Application no: 23/03606/DISC

Location: The Innovation Quarter, Bicester Heritage, Buckingham Road, Bicester, OX26 5HA

Transport Development Management

Title  
**Phase 1 - Turning Area**

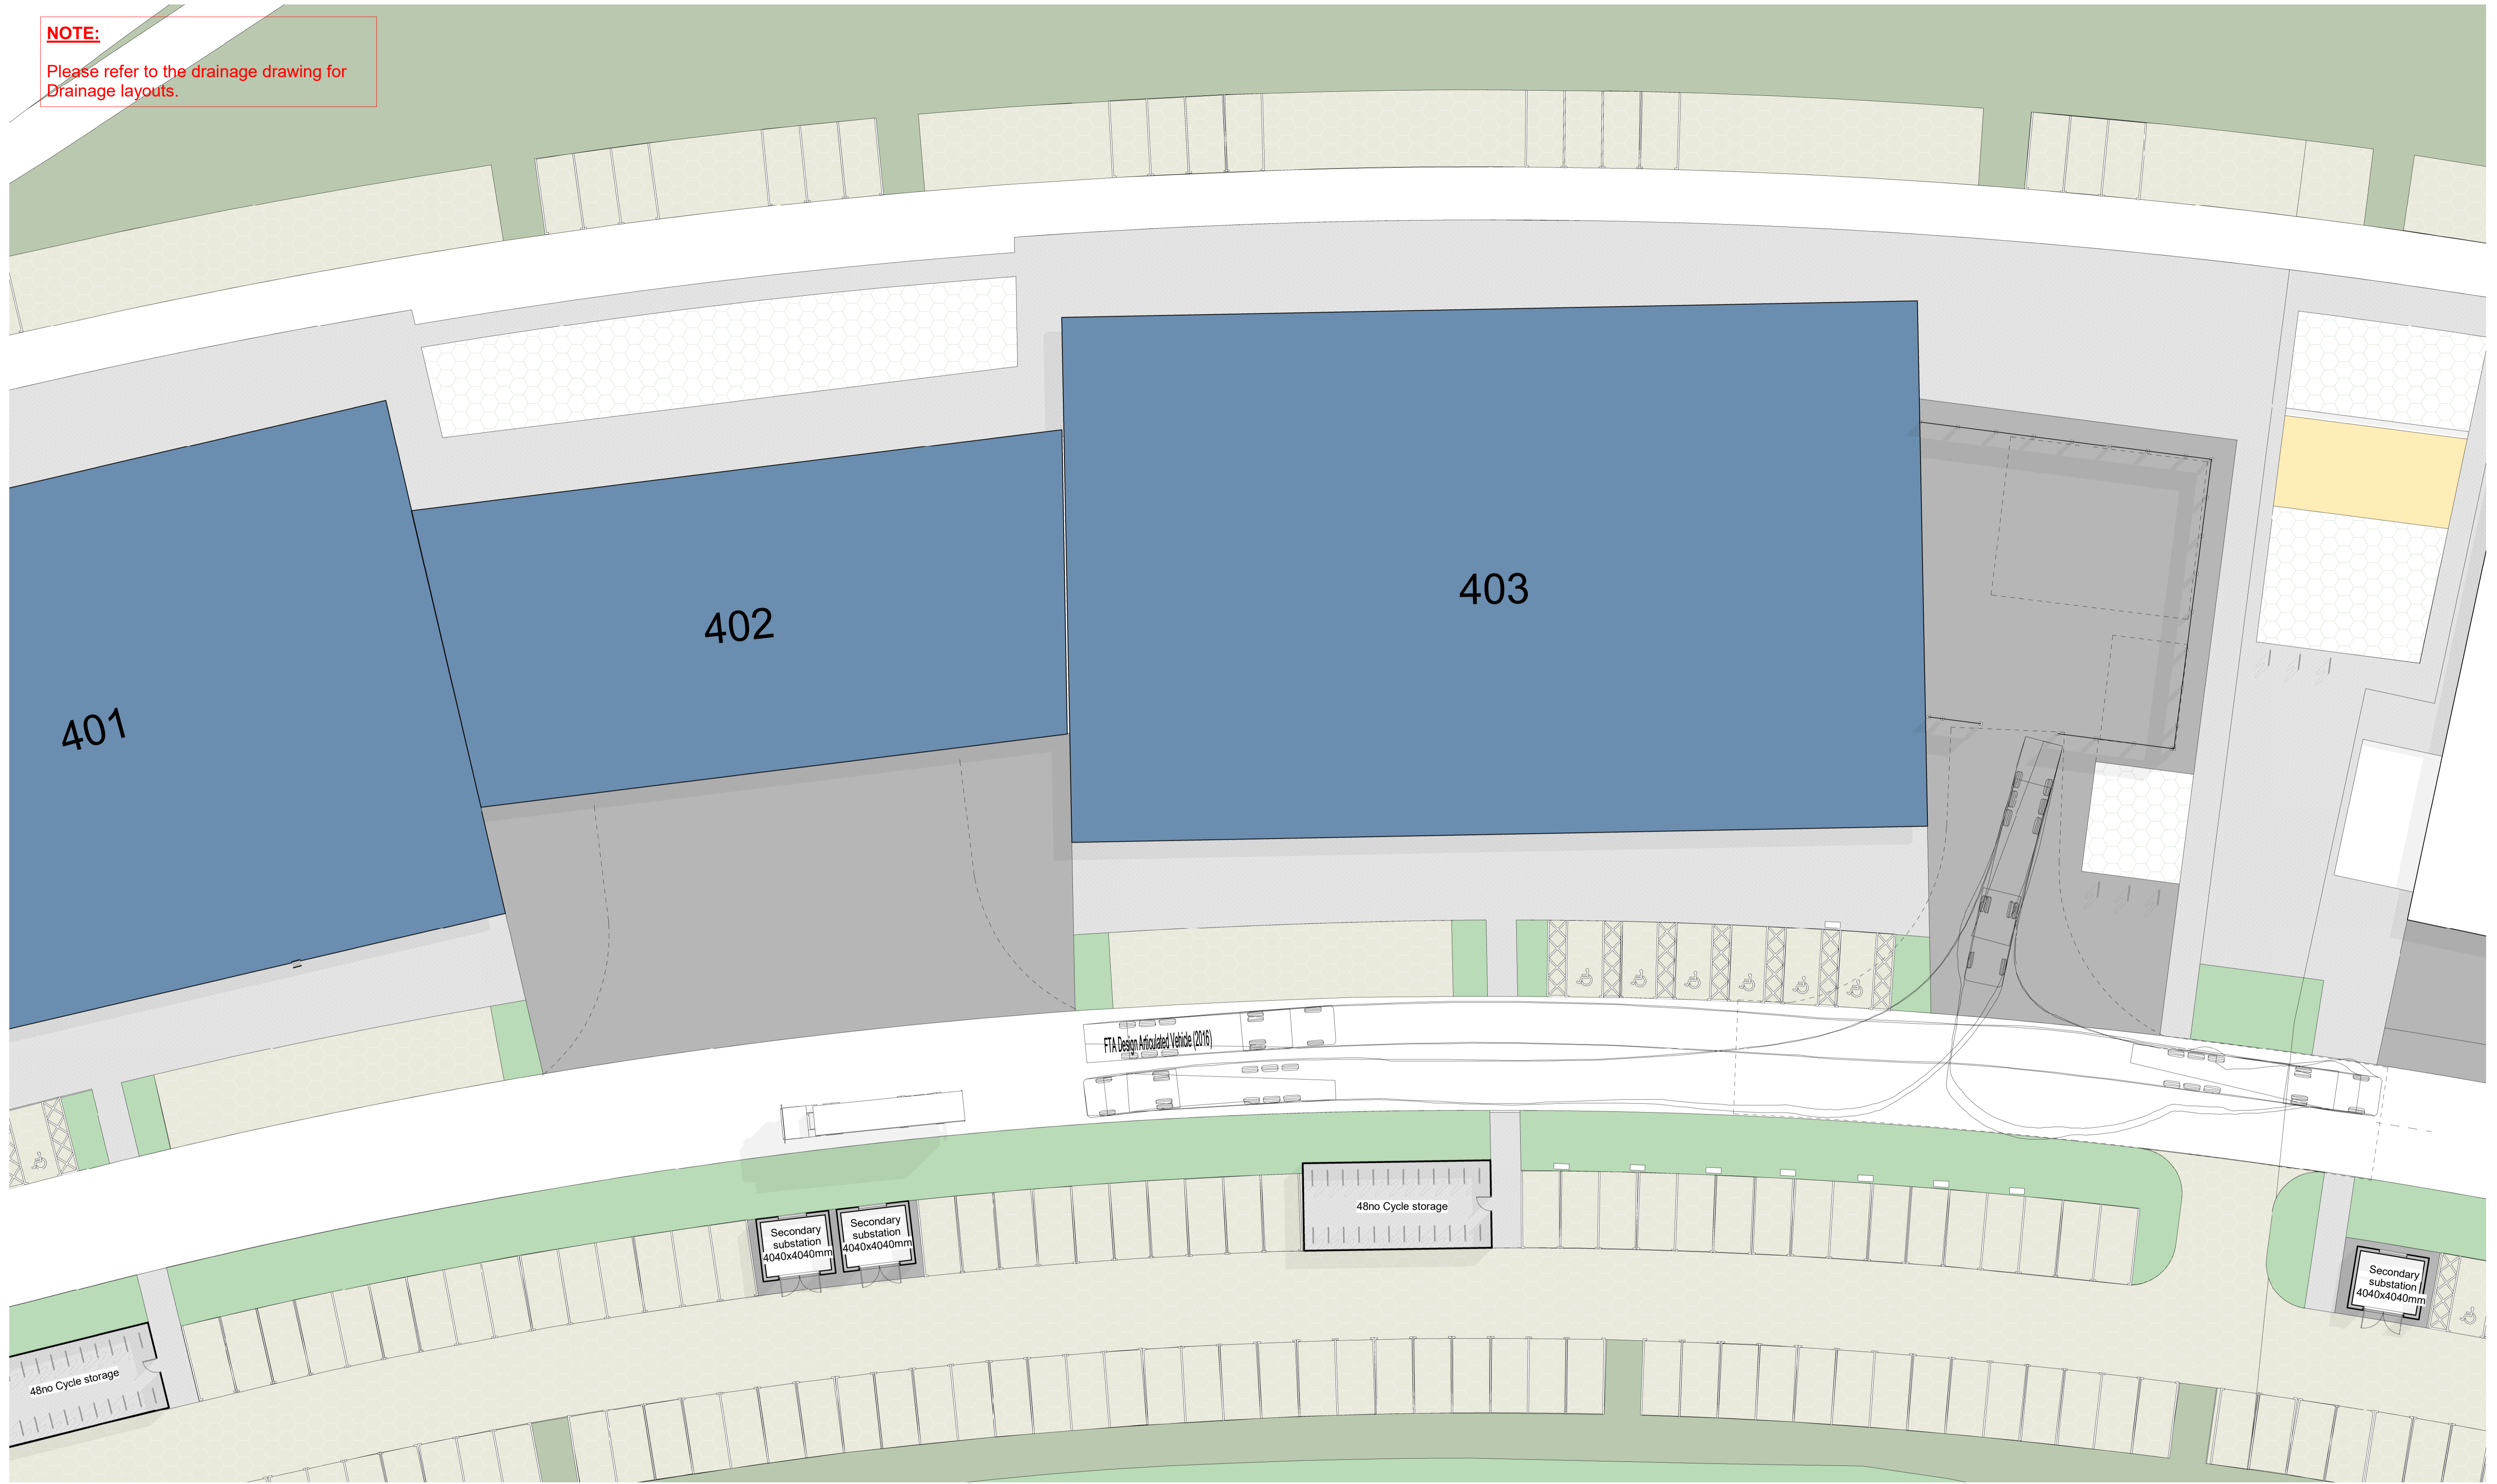
I consider the plans submitted to discharge this condition are appropriate.
